Our Ref: R/185/19/NMA

**Section 96A of the Town & Country Planning Act 1990 (as amended)
Town and Country Planning (Development Management Procedure) (England) Order 2015 (as amended) - Article 10**

Non-material amendment following the grant of reference R/178/16/HH to add lantern skylight to roof and replace single door and window with 3m bi fold door to rear of extension.

28 Ruston Avenue Rustington BN16 2AN

BLOCK PLAN.

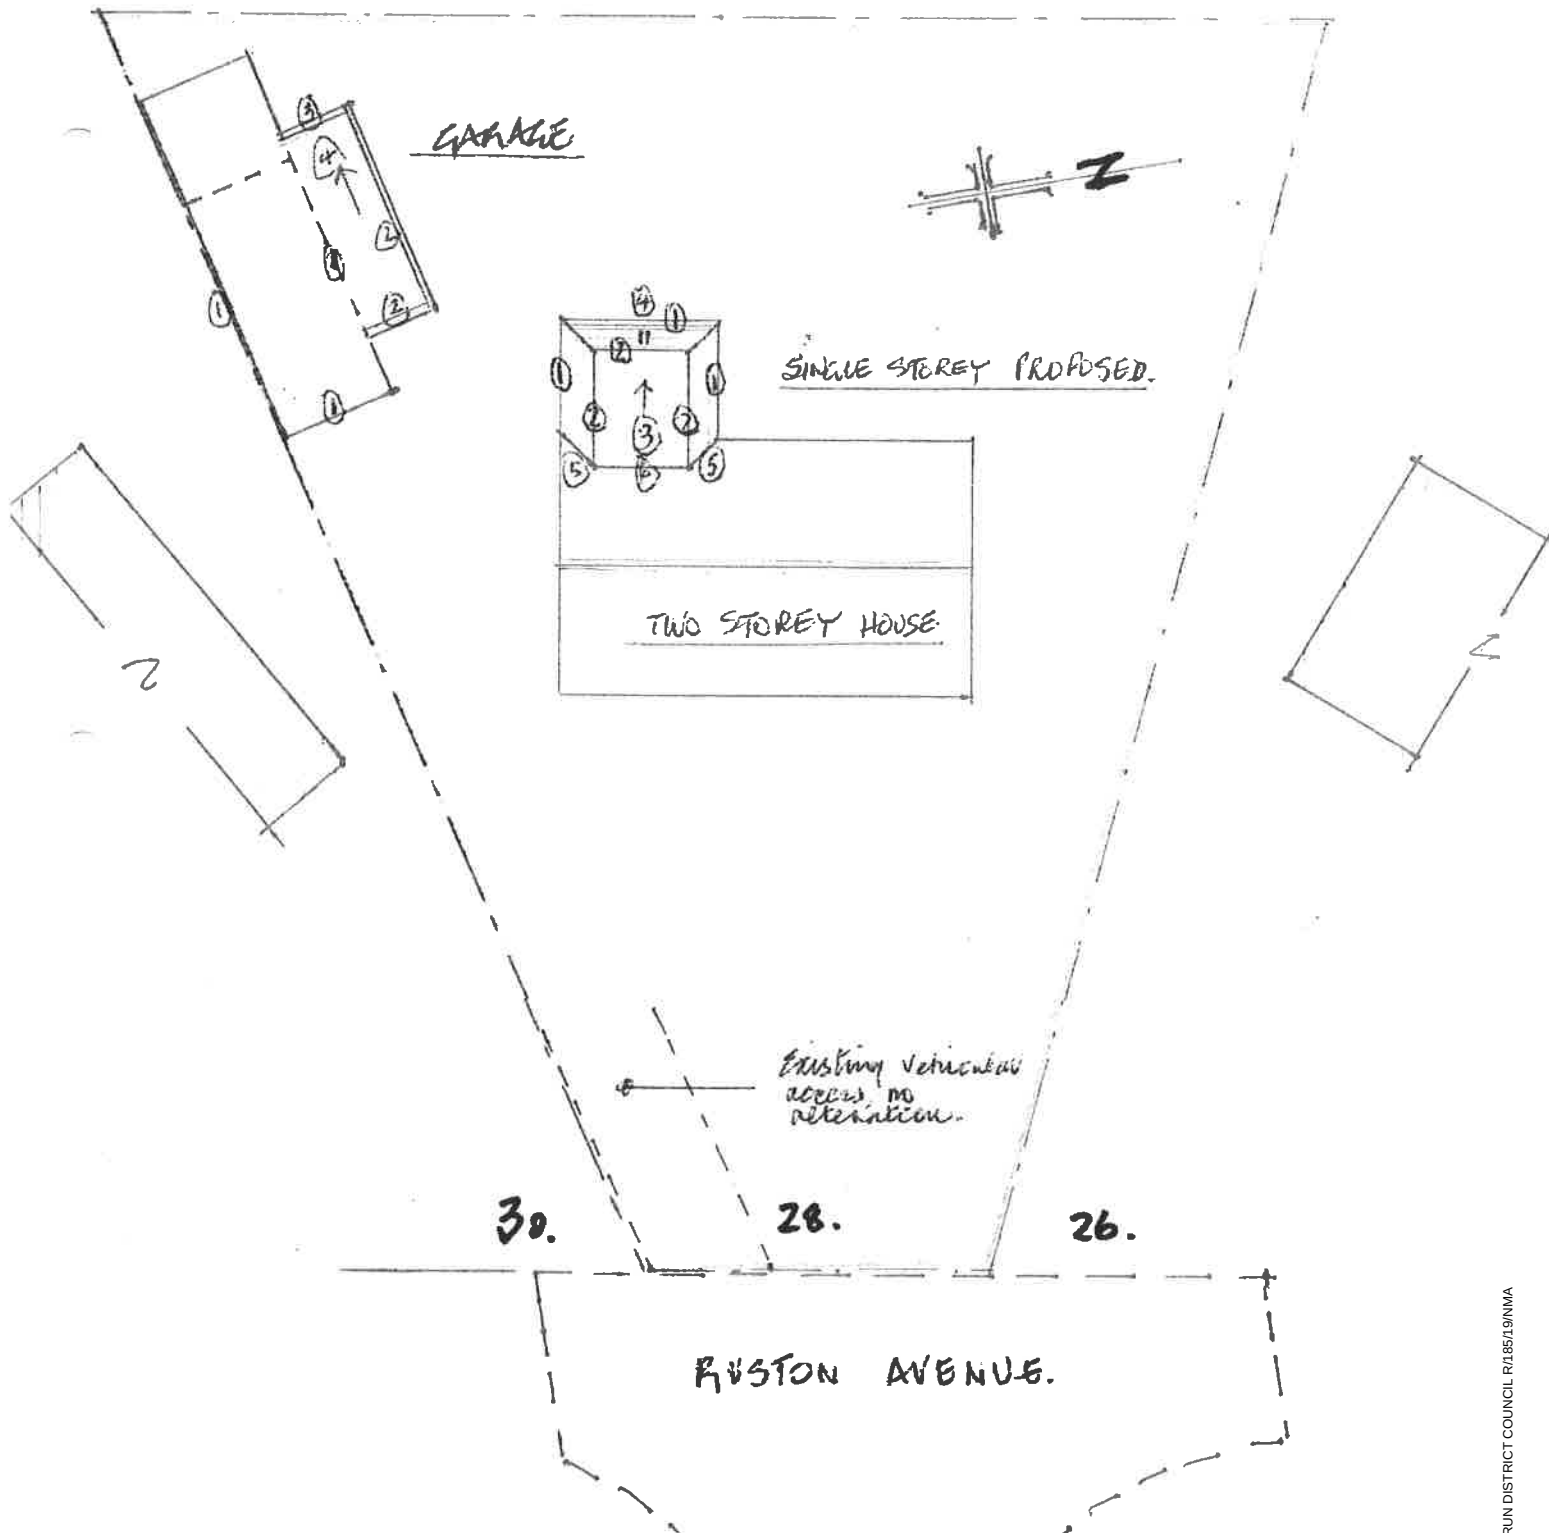
Please note that plans 'Existing & Proposed Elevations - ARD/540/5 - July 2016' is replaced by 'Proposed REAR ELEVATION - Proposed FLOOR PLAN'. This plan also supersedes 'Block Plan - ARD/540/2a - July 2016' but only in relation to the Roof Detail, and Roof Form.

Drwg. ARD/540/5

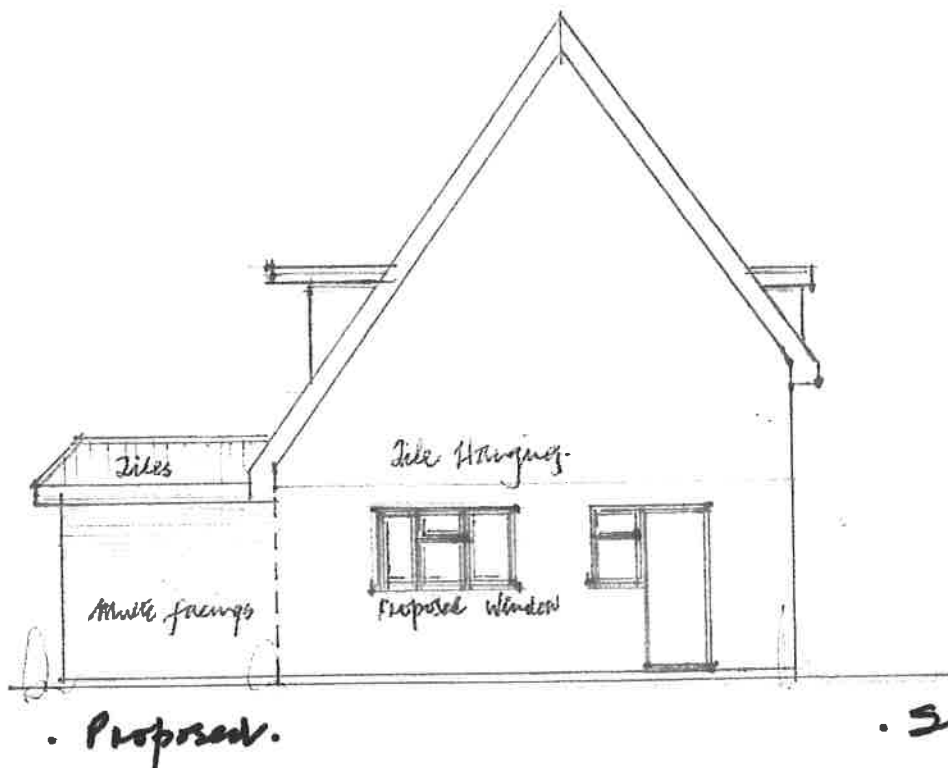
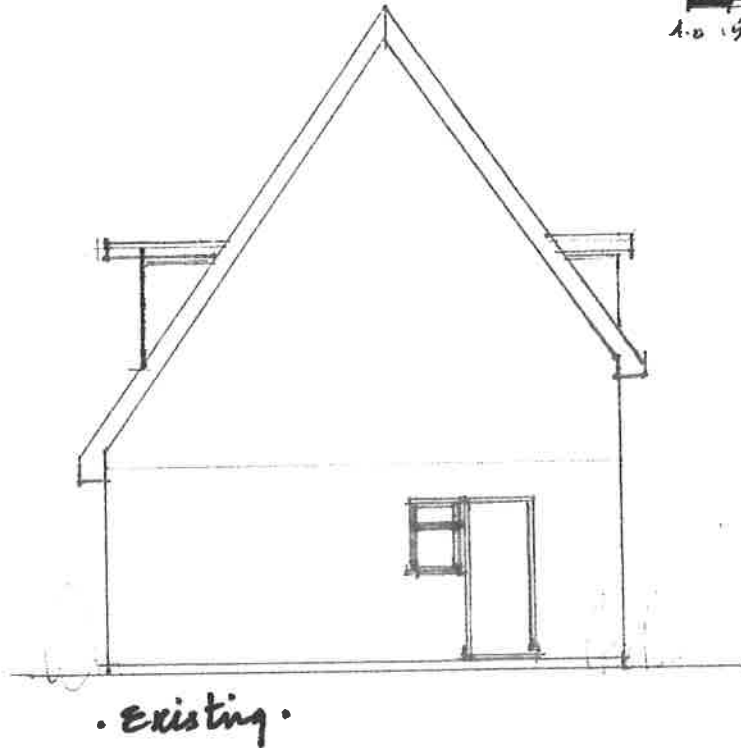
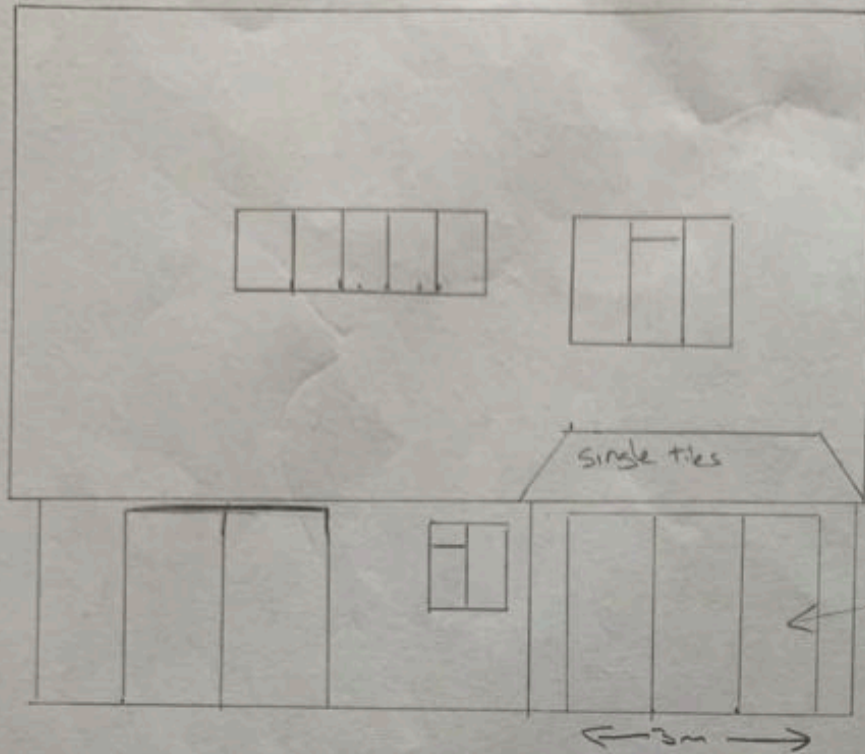
I refer to your recent application for a Non Material Minor Amendment. I note that you seek to add a lantern skylight to the roof of the extension, and replace the single rear door and window with a bi-fold door.
